From: Simon Davis
Sent: 14 April 2021 13:23
To: Myles [REDACTED]
Subject: RE: Planning Ref: BR/81/21/CLE

I have been thinking about your application some more and I have to advise that notwithstanding the query on number of people, we cannot grant you a Certificate under the application that you have made. This is because you have applied for a Certificate of Existing Use/Development (CLE) which is relevant for when someone has been operating a HMO use for 10 years and is seeking confirmation that such a use is now immune from enforcement action. You should have applied for a Certificate of Proposed Use/Development (CLP) which is appropriate where someone is seeking confirmation that a use they are proposing to commence does not require full planning permission/is permitted development.

Proposed - Ground Floor

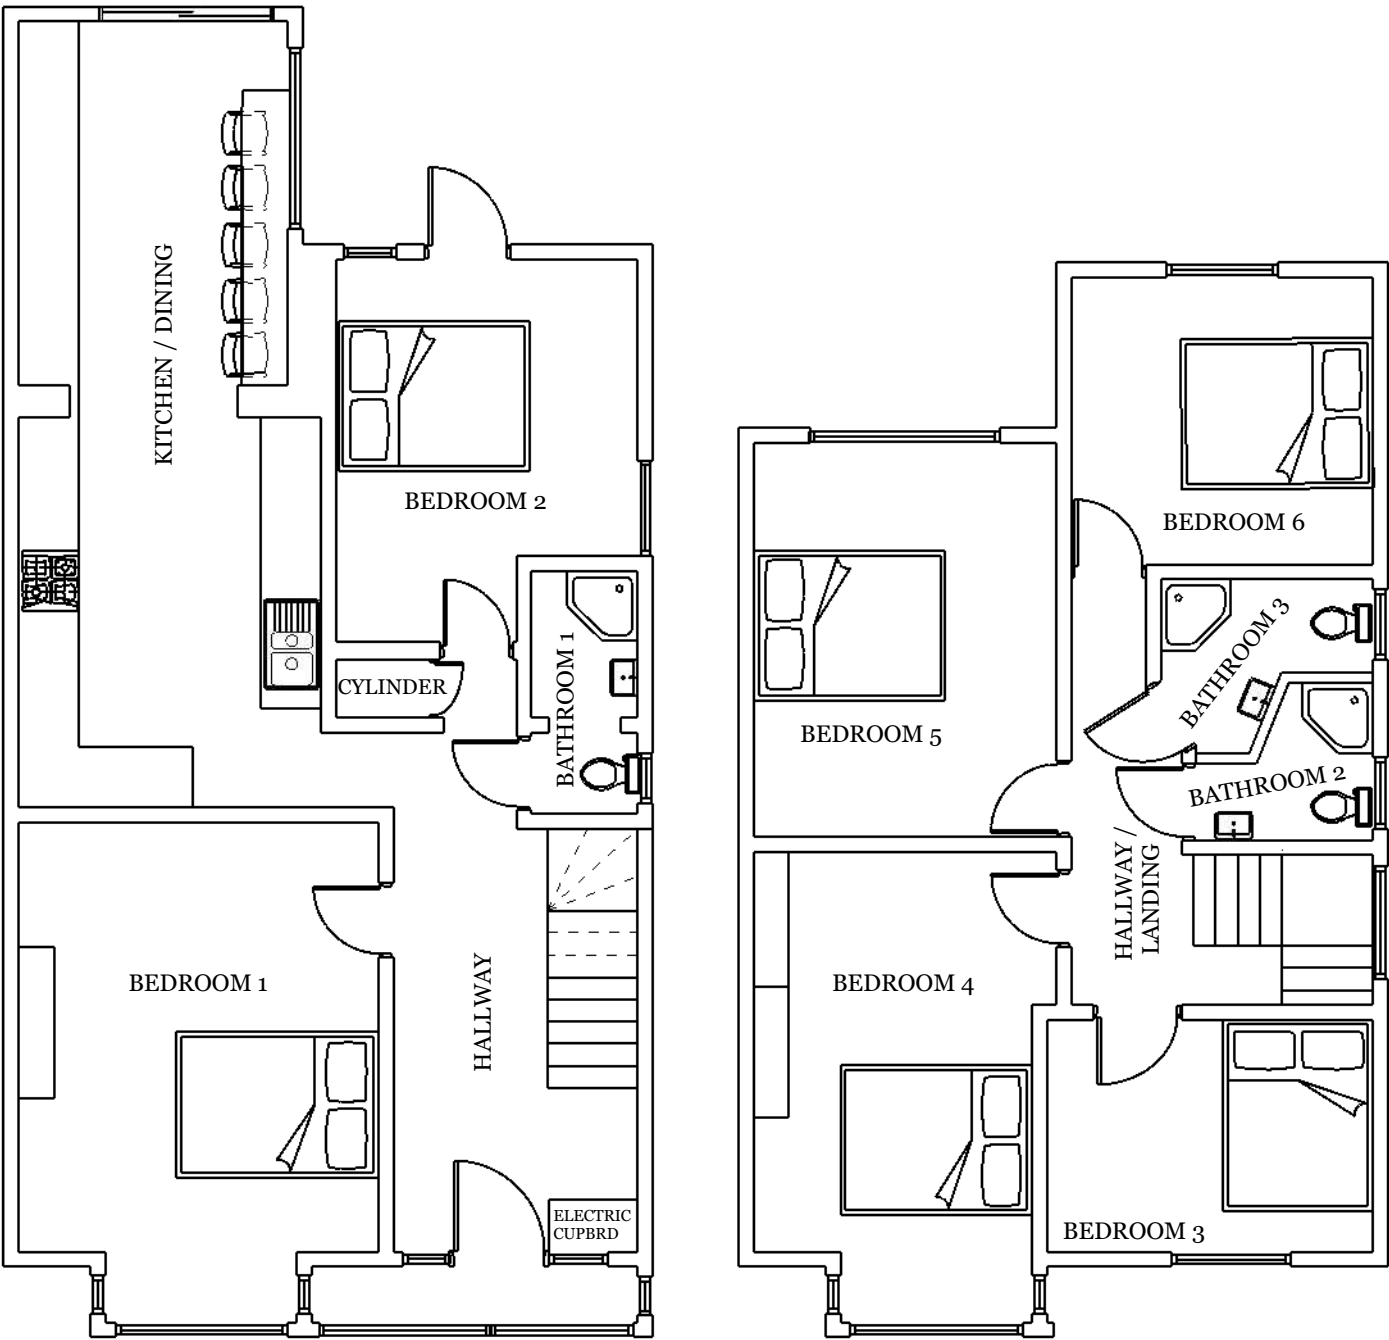
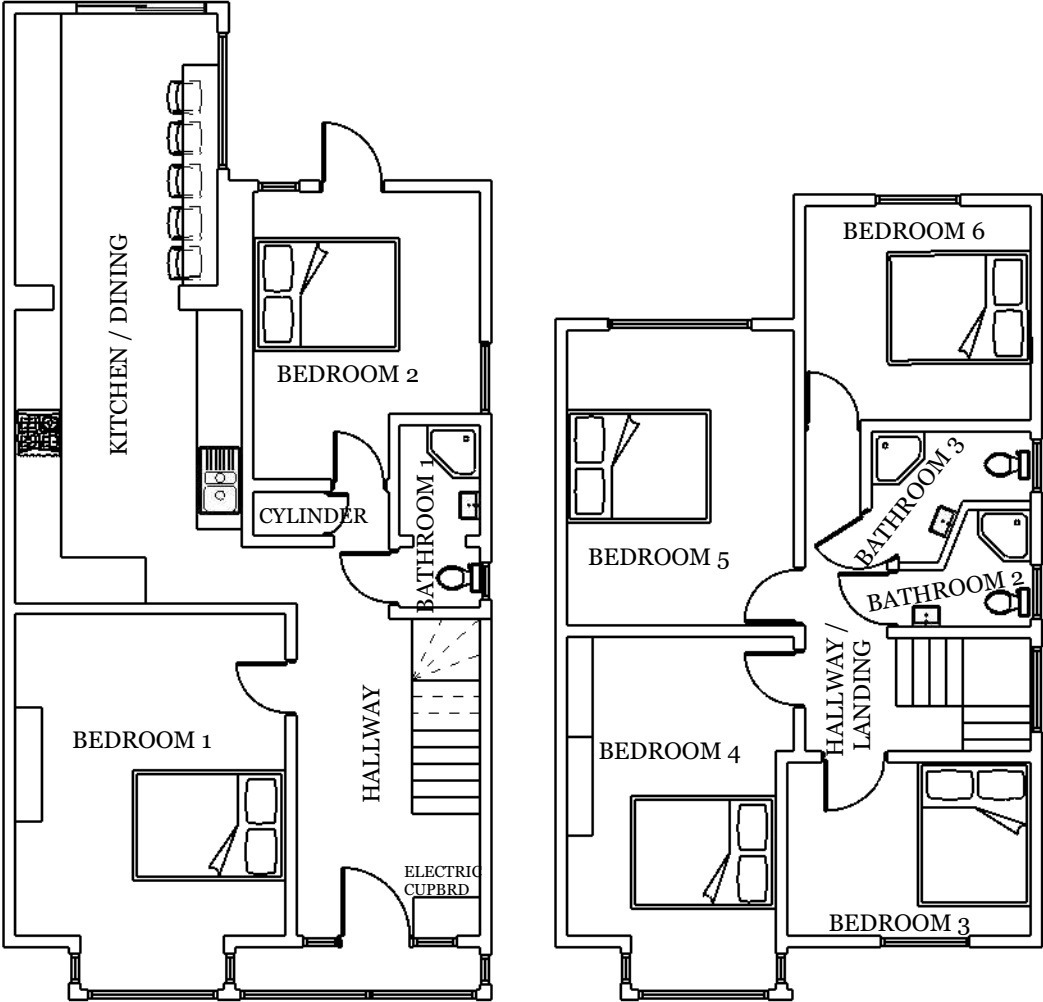
To correct the scale, the drawing would need to be re-drawn at a different scale – at say 1:50 or 1:100. This would then allow us to measure the rooms and work out the floor areas.

I am currently your case officer although this may yet be reallocated to an alternative officer. However, in the meantime, I have been contacted by our Environmental Health Officer (EHO) who has asked if you can confirm how many occupants you intends to have as tenants in this property please? We note that the application is for a 6 bedroom HMO but the floorplans also appear to show double beds in all rooms. The EHO also asks that you provide room sizes in m2.

Please also note that our system does not allow us to electronically scale from 1:75 plans. Those in the following screenshot are the only options we have. Would it be possible to provide a new floorplan in a different scale and then also annotate/provide a key with the room sizes.

I think I have attached the drawing in the correct scale now.
